# CITY OF ALBUQUERQUE

## **Planning Department Transportation Development Services**

**Re: Chili's, 1700 Miles Rd, SE**  
**30-Day Temporary Certificate of Occupancy- Transportation Development**  
Engineer's Stamp dated 12-31-14  
Certification dated 10-08-15

RONALD R. BOHANNAN P.E. #7868	CHILI'S UNIVERSITY BLVD & GIBSON BLVD	DRAWN BY DY
	GRADING AND DRAINAGE PLAN	DATE 12/30/14
 TIERRA WEST, LLC 5571 MIDWAY PARK PLACE NE ALBUQUERQUE, NM 87109 (505) 858-3100 www.tierrawestllc.com	SHEET # C3	JOB # 2013086
	2013086-CRE

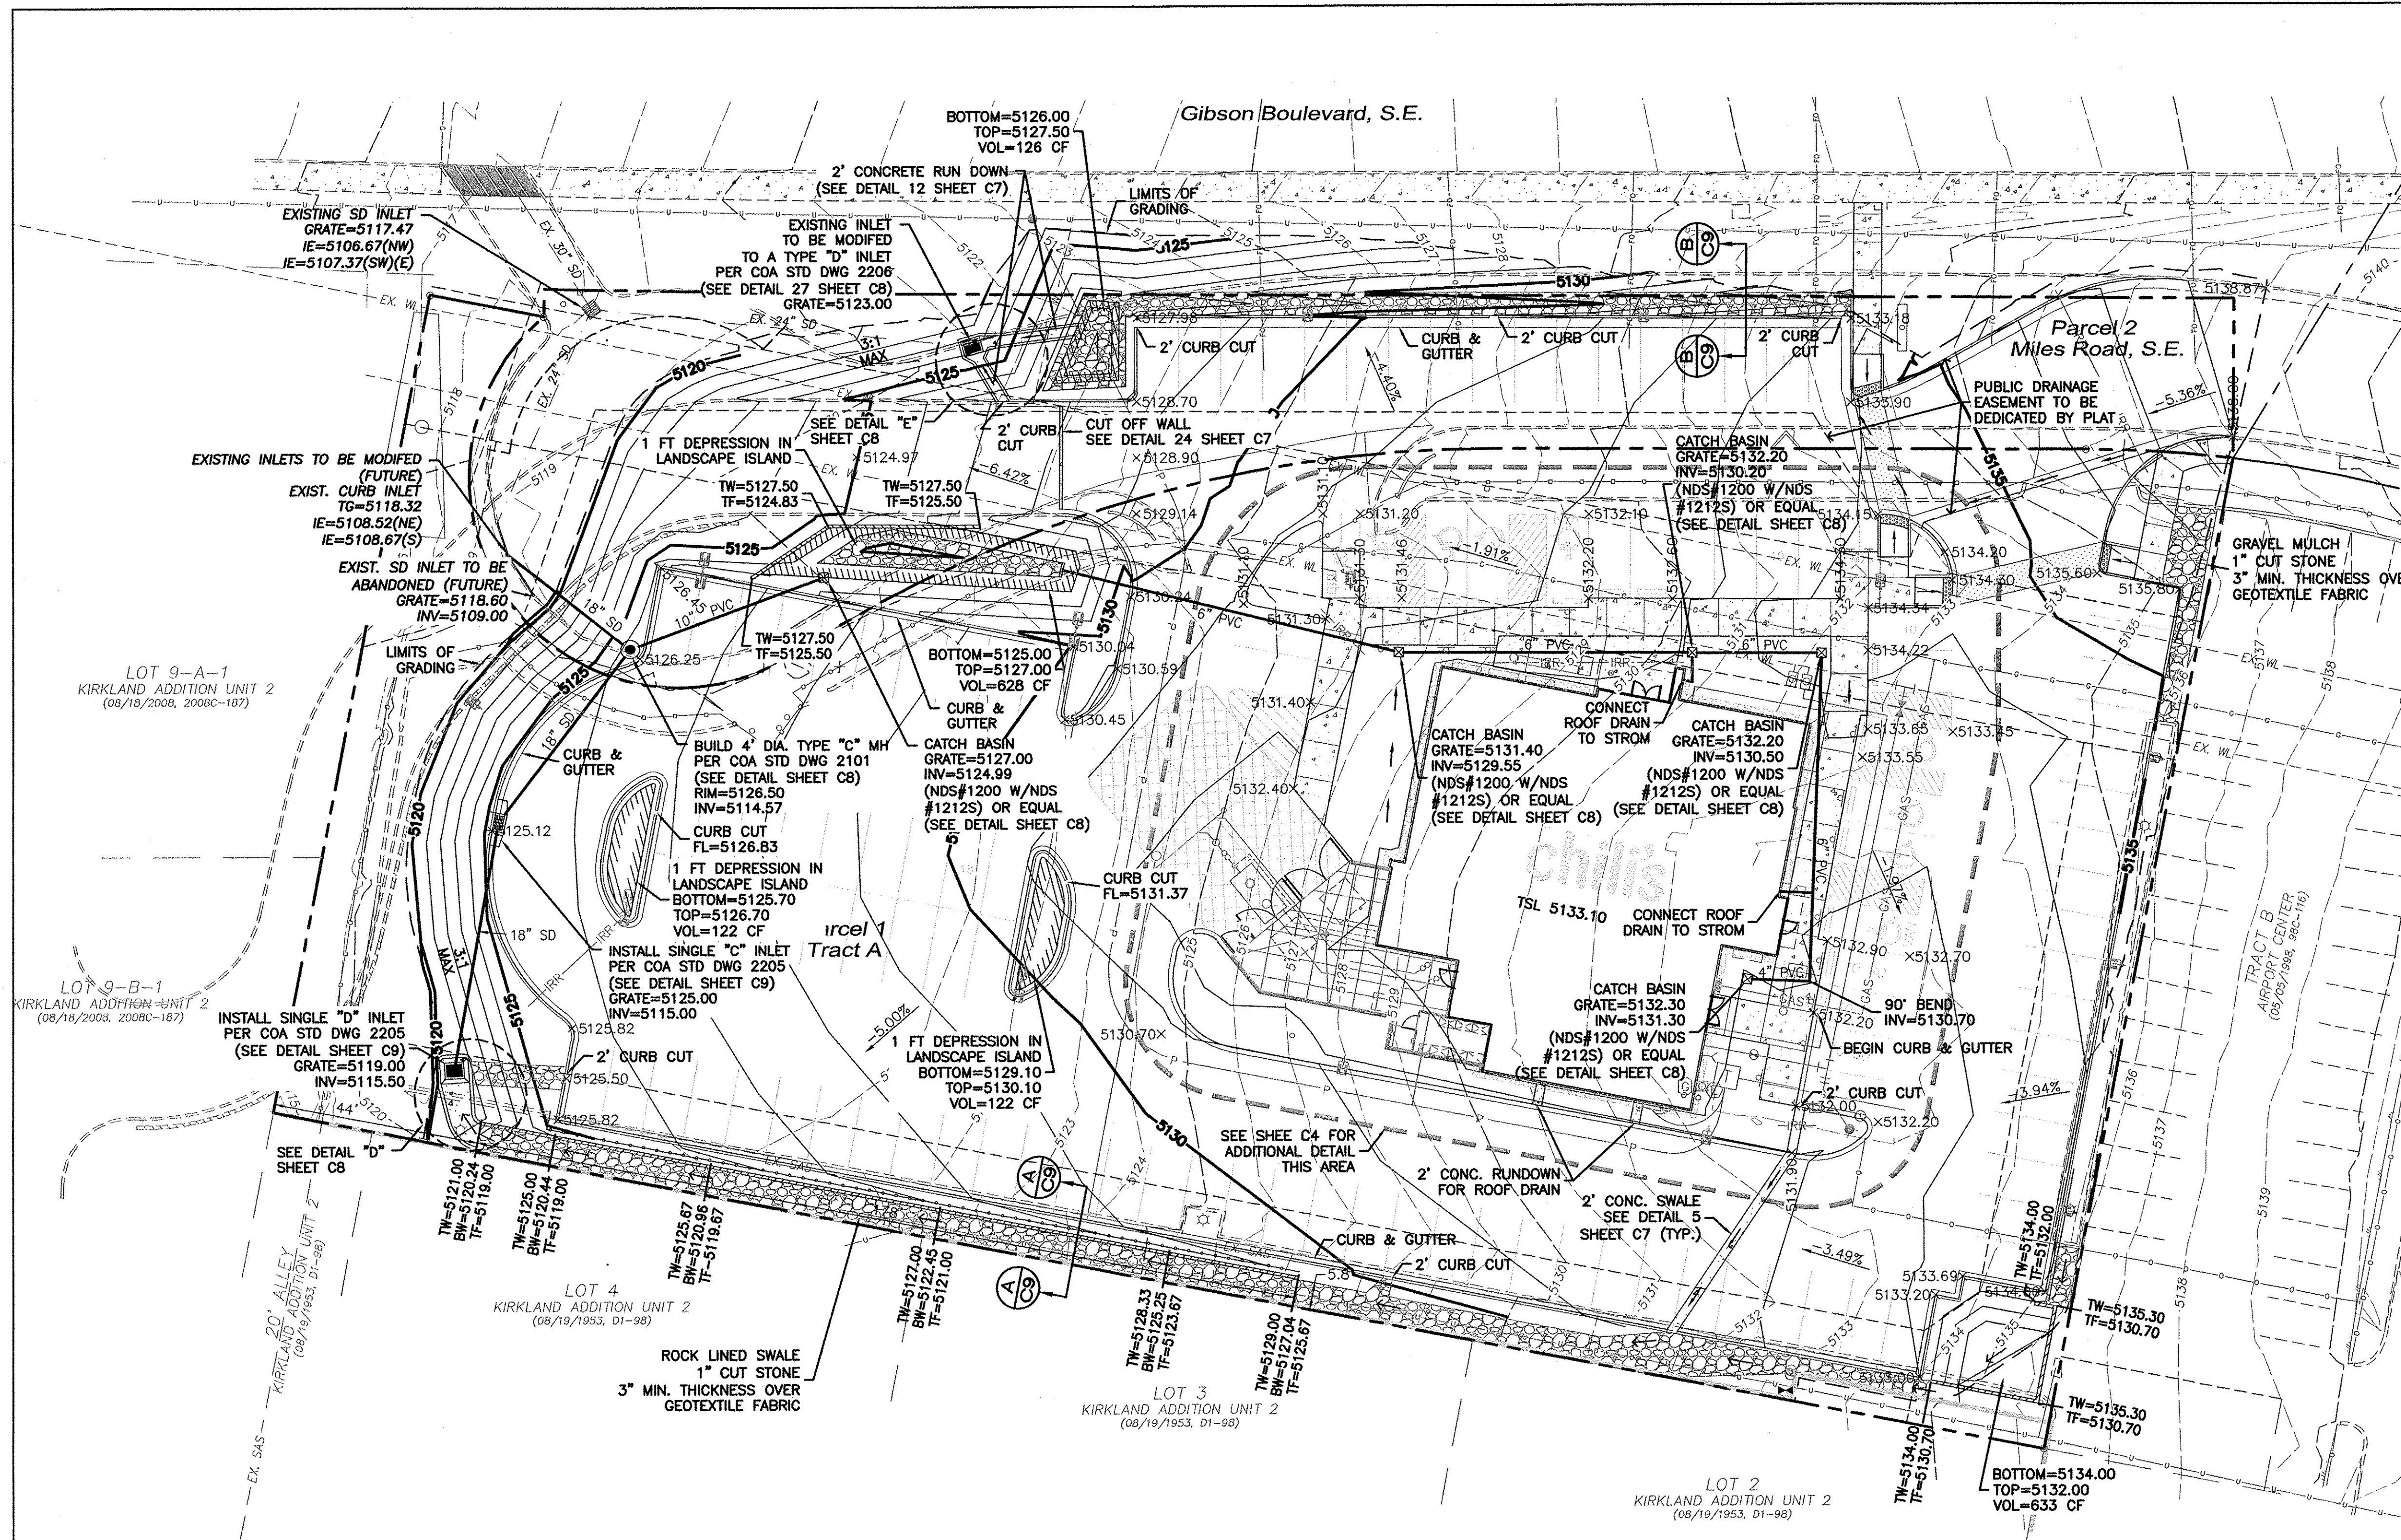
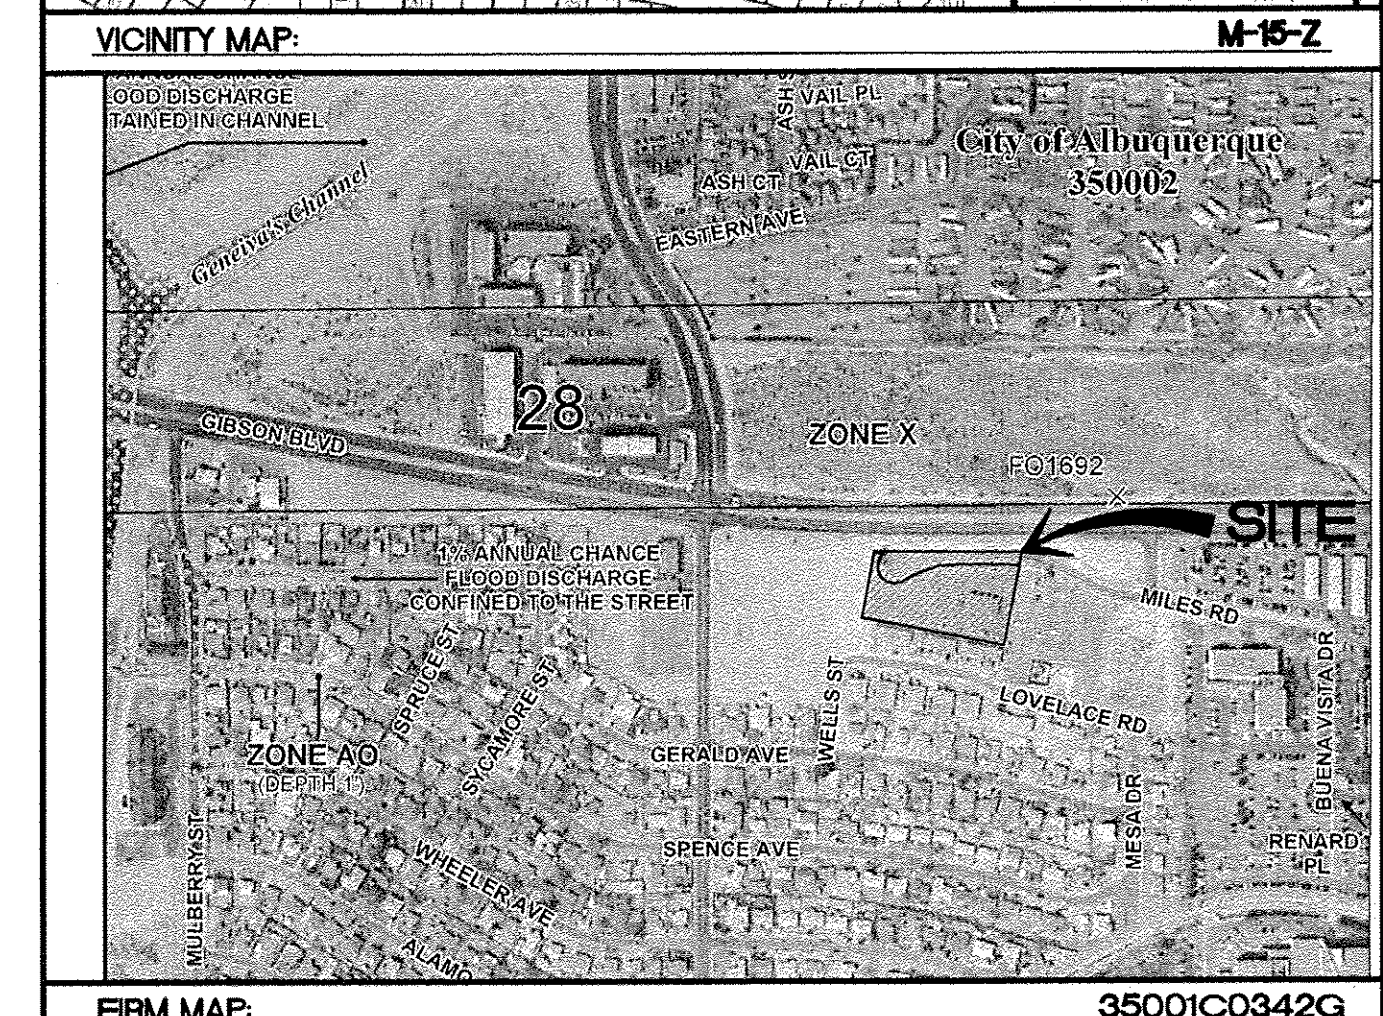
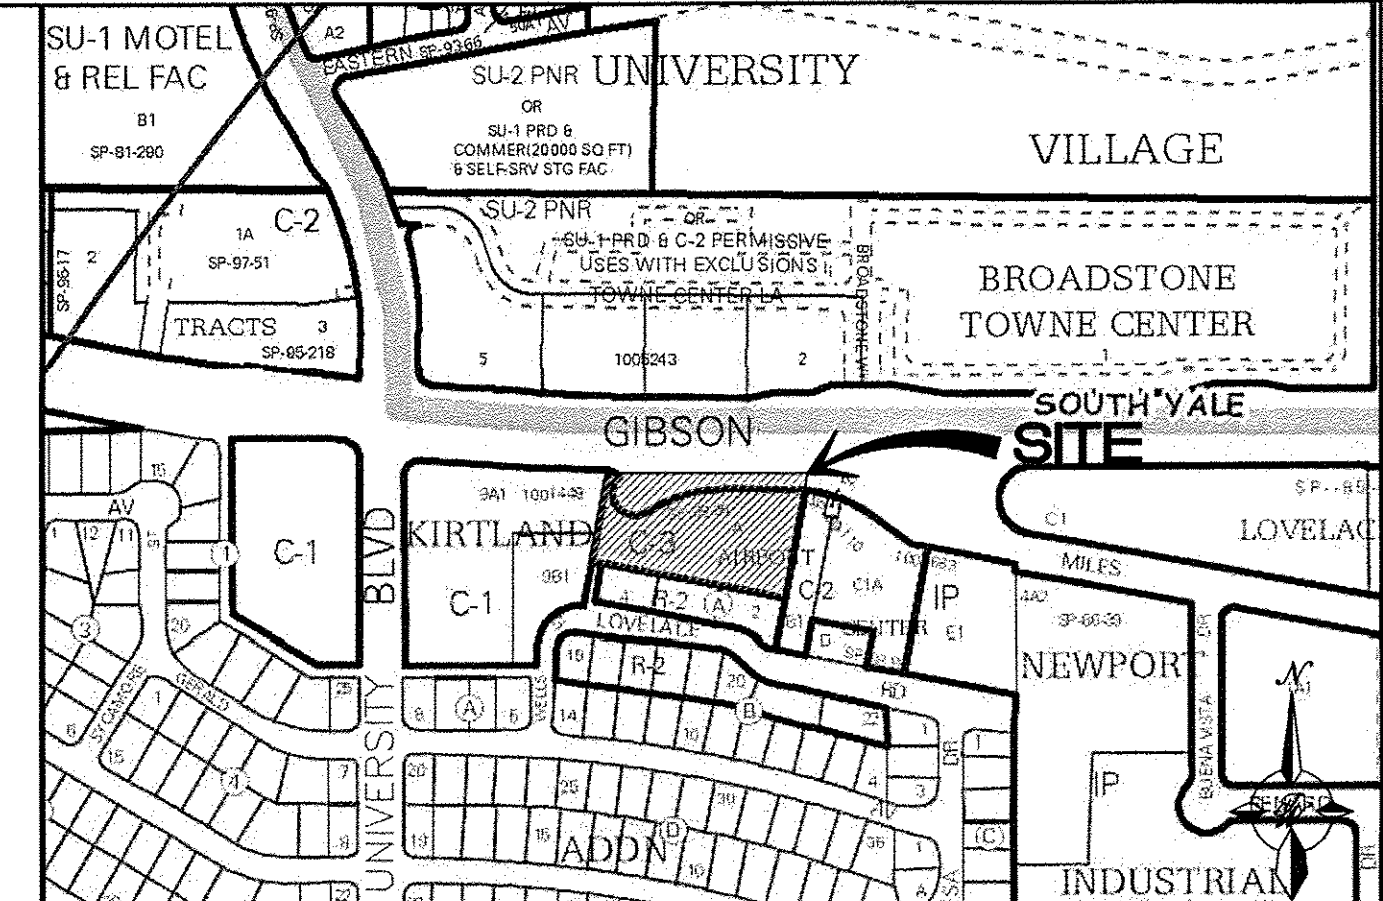
- Sidewalk slope on the northeast corner of the site shall be reduced so as not to exceed 5%, with a maximum cross slope of 2%.
- All construction debris and dumpster removed.
